DRB Application No.: *11DRB-70308*

Project Name: *Paris Addition*

PROPOSED EVENTS CENTER AT 1510/1512 FIRST STREET, ALBUQUERQUE, NM

OFFICIAL NOTIFICATION OF DECISION

ELEVATIONS

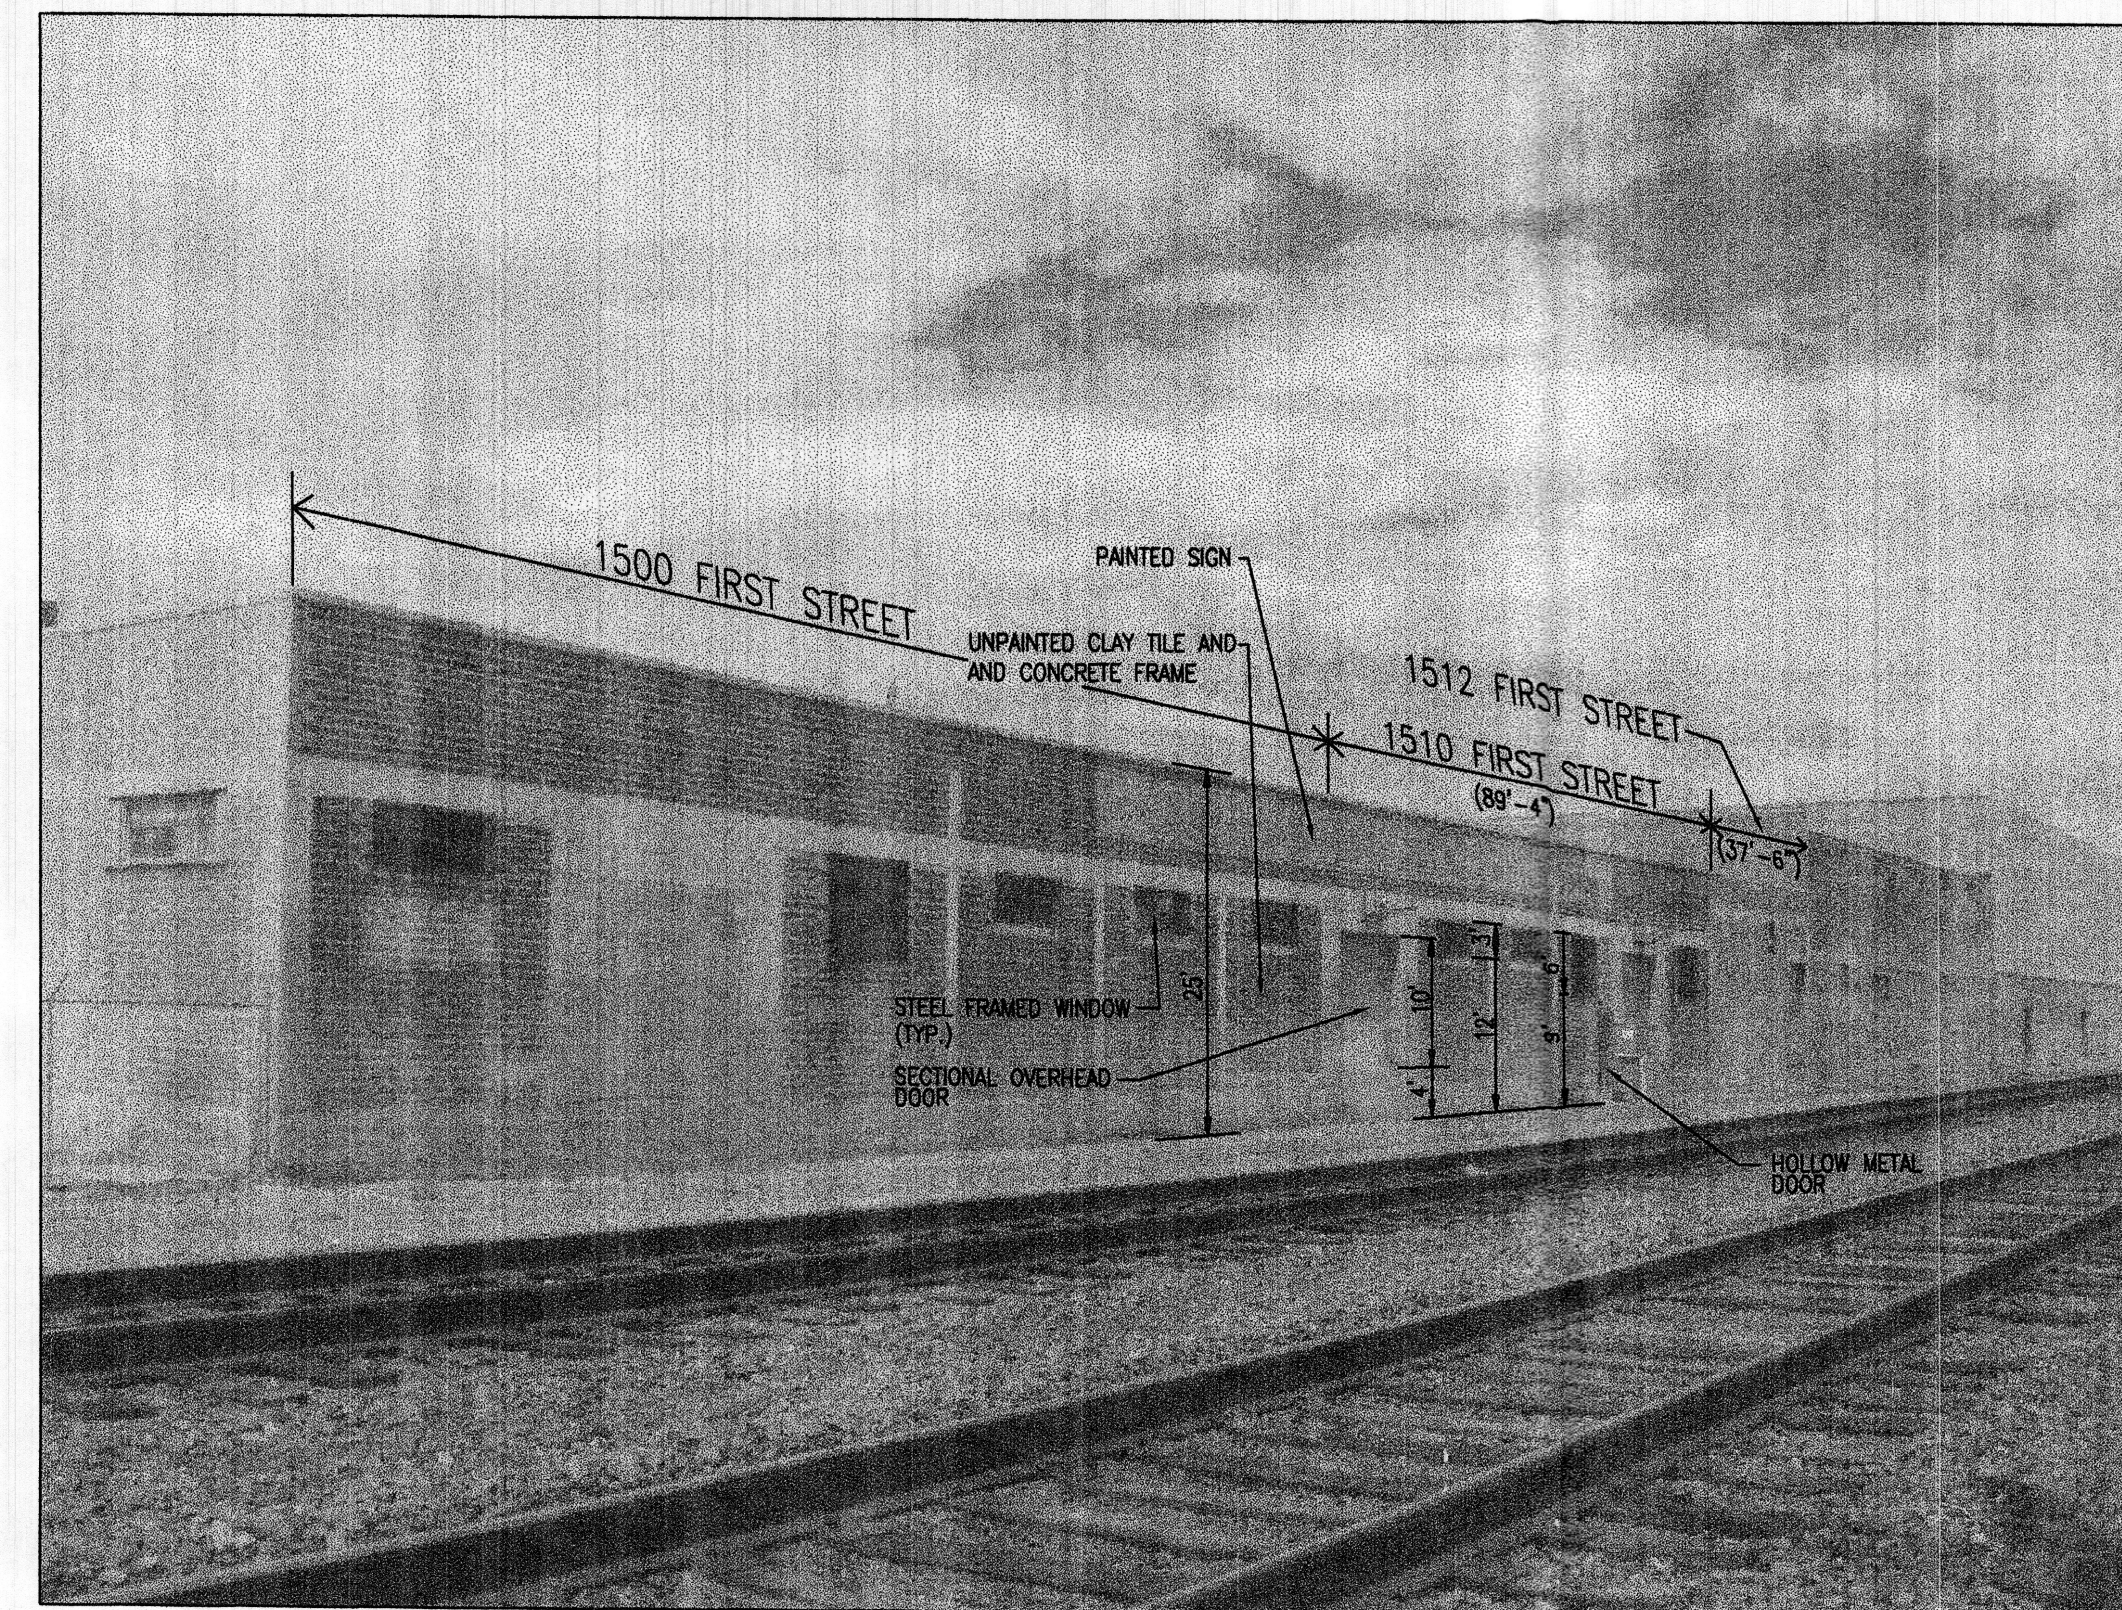
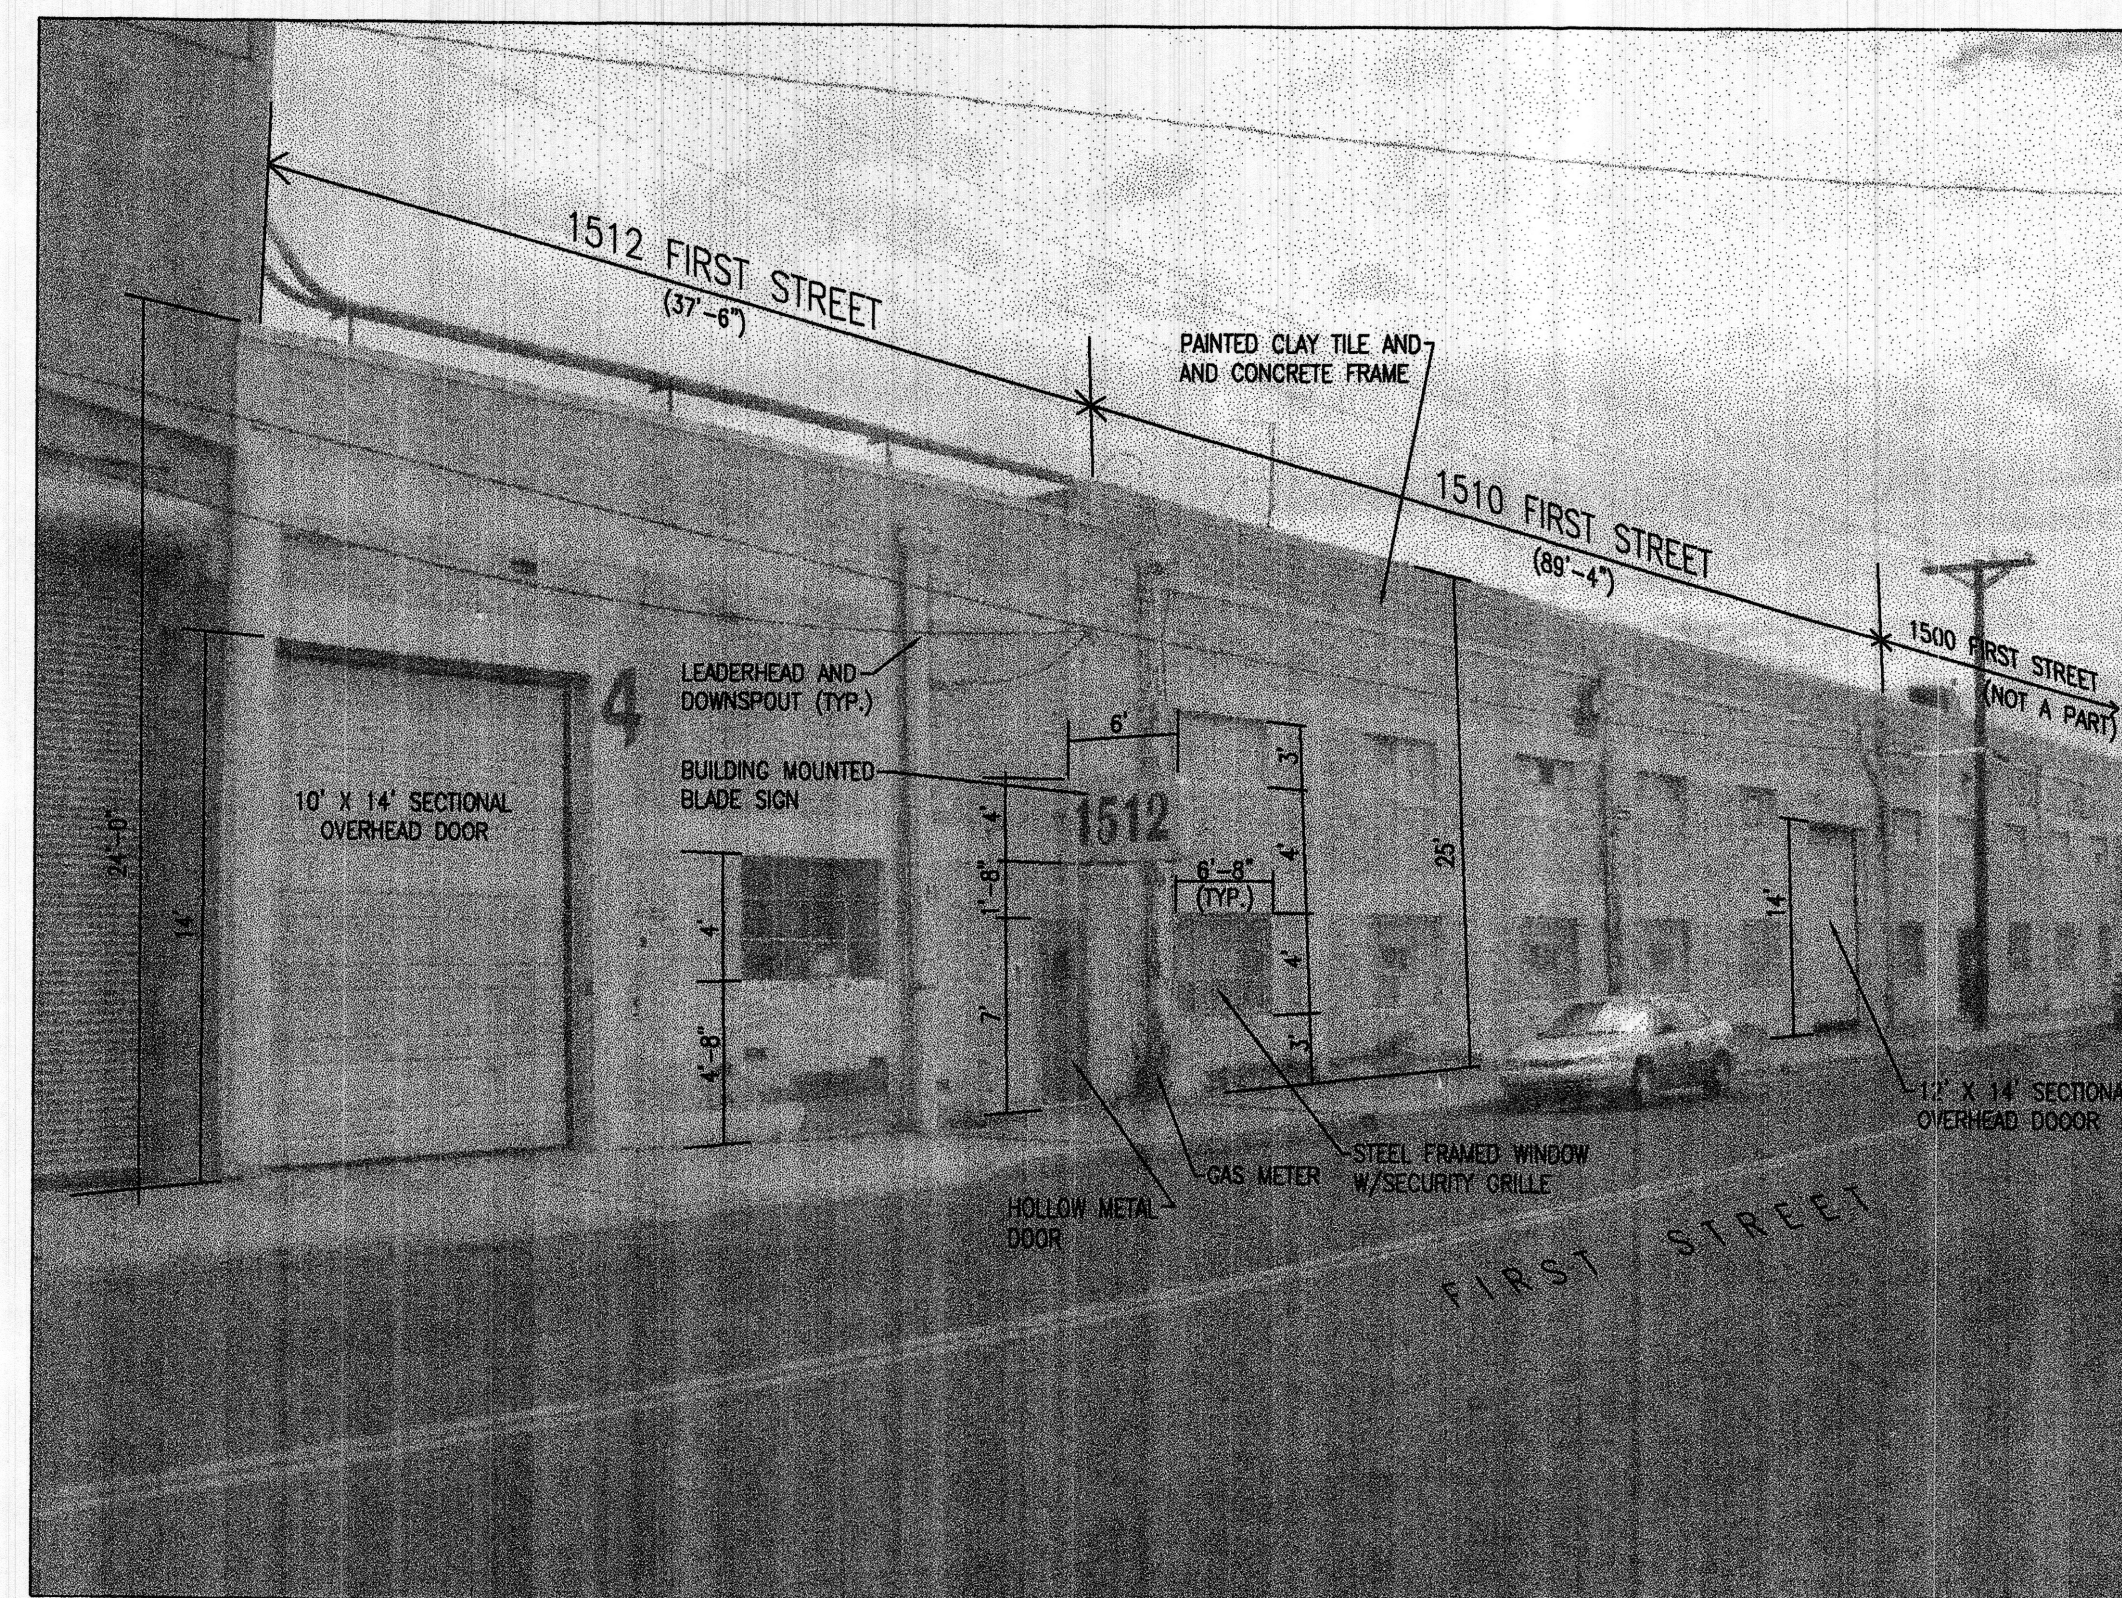
8. The applicant has submitted a site development plan that shows the building’s footprint on the subject site, but has failed to show the buildings dimensions and dimensions for the windows and doors.

Condition 5: Dimensions for the existing building doors and windows have been added to the Site Development Plan and also to the Building Elevations. The correct zoning description and definition of "Events Center" as printed in the notice of decision have been added to the Site Data on the Site Development Plan.
